Our Ref: WA/12/18/PL
Your Ref:

Town & Country Planning Act 1990 (as amended)
Town and Country Planning (Development Management Procedure) (England) Order 2015
Application for Planning Permission

Development Replacement sales building, canopy link removed, new bin store, delivery bay, front of store customer parking & 2 No new electric charging points.

Location Shell Filling Station Arundel Road Fontwell

TITLE : ELECTRIC CHARGING POINT

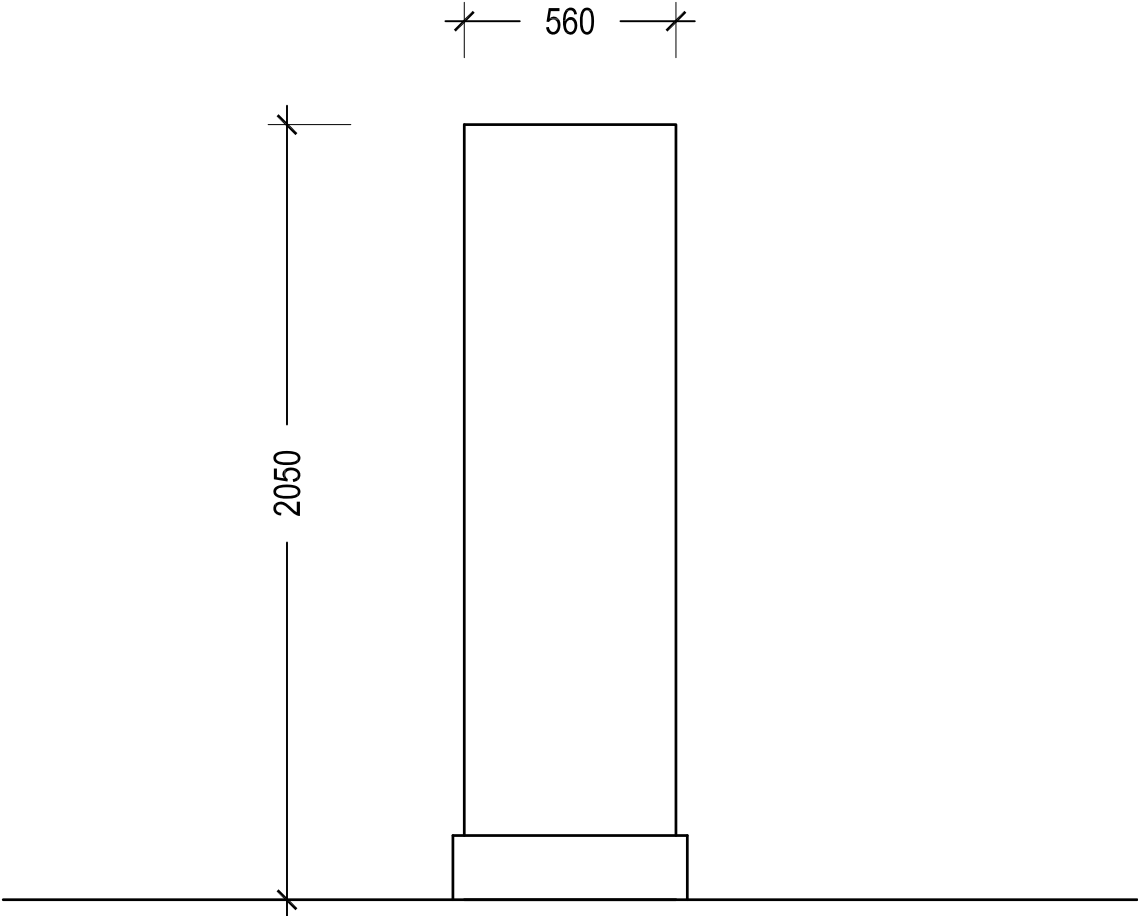
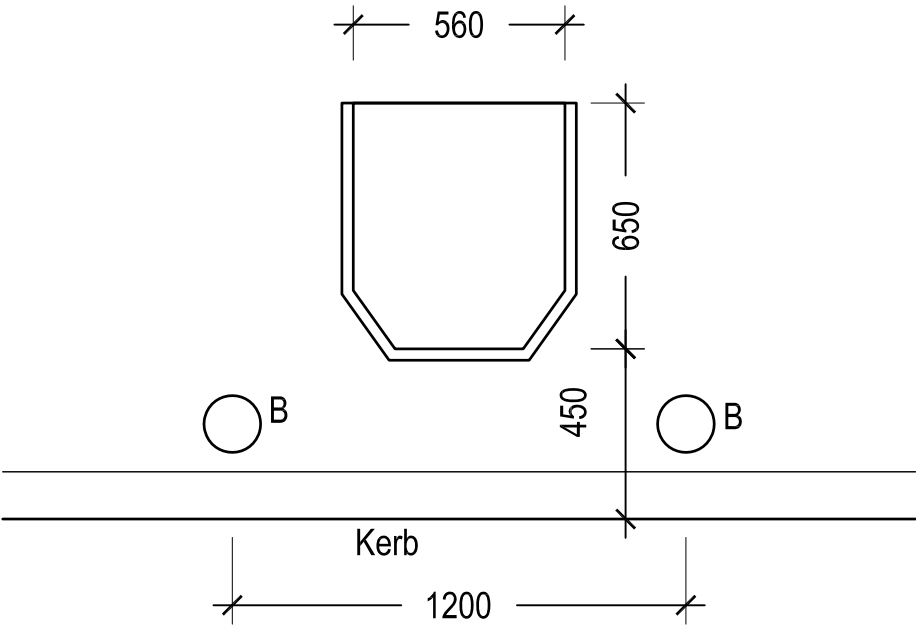
Please provide a section of the electrical charging points.
